Re: Application No. EG/33/11 - Greenoaks

Reference: Greenoaks Eastergate EG/33/11

RBA 895 - 50 P8

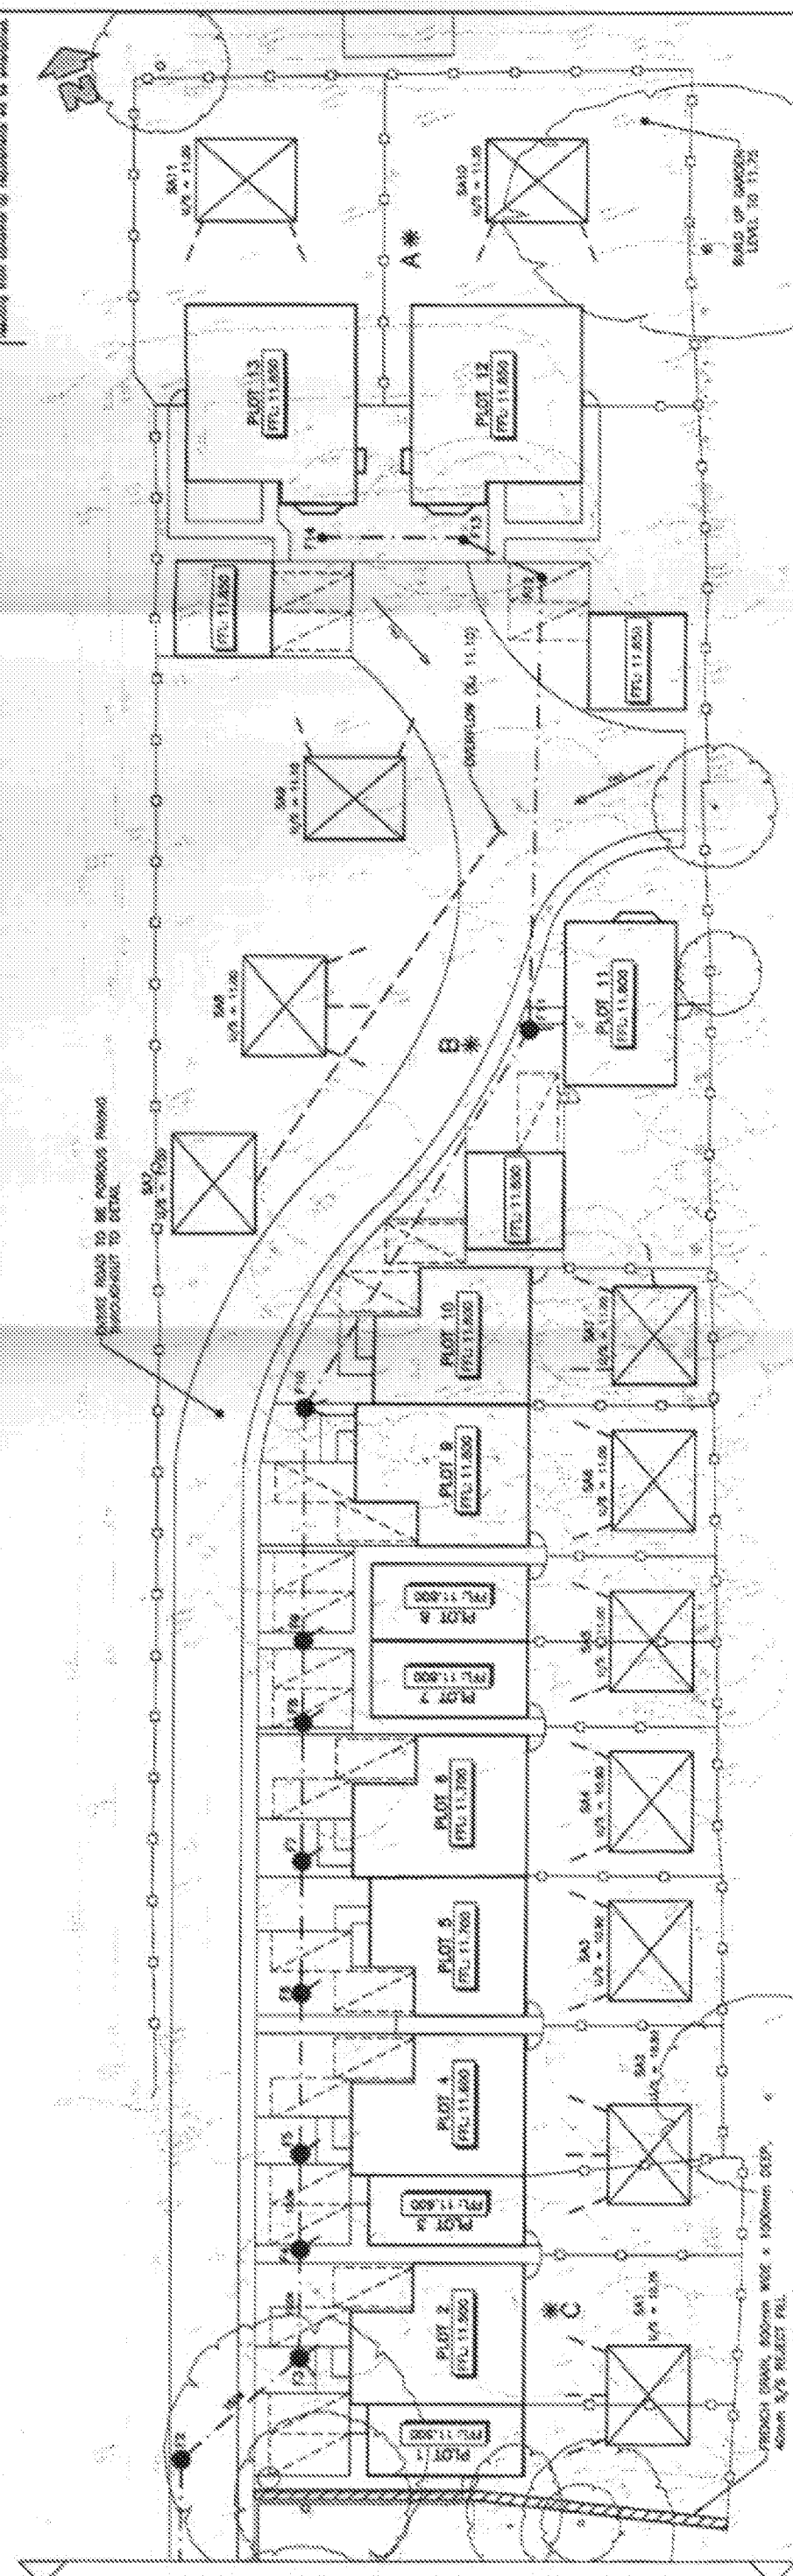
I believe that the proposed development will exacerbate the already serious flooding and sewerage problems of the Barnham area. Note the invert levels of manholes 1-11 shown on the developer's drawing RBA895/50 are all below the groundwater level. As already mentioned it is the fact that the foul sewer is below the water table that is causing much of the flooding/surcharging issues. How will the developer keep the manholes water tight without stressing the connecting pipes and ensuring that the manholes do not "float" in winter and "sink" in summer due to the flexing of the clay soil.

All the soakaways in the back gardens as indicated on drawing RBA895/50 are less than 5 meters from the houses and three are shown under the fence, four are under the cycle sheds. Please will you request from the developer for a more detailed assessment as to what his exact intentions are.

The same drawing shows 10 surface water soakaways and a French drain have been placed less than 2 metres from the proposed tree, hedge and shrub planting. An expert I have consulted states that such proximity will seriously threaten the survival chances for most of the planned planting.

I suspect that the arboriculturalists have not reviewed the drainage plans and that the drainage engineers have not reviewed the planting schemes. The developers drawing RBA895/50 clearly states in bold
"DRAINAGE LAYOUT SUBJECT TO ARBORICULTURAL REVIEW"
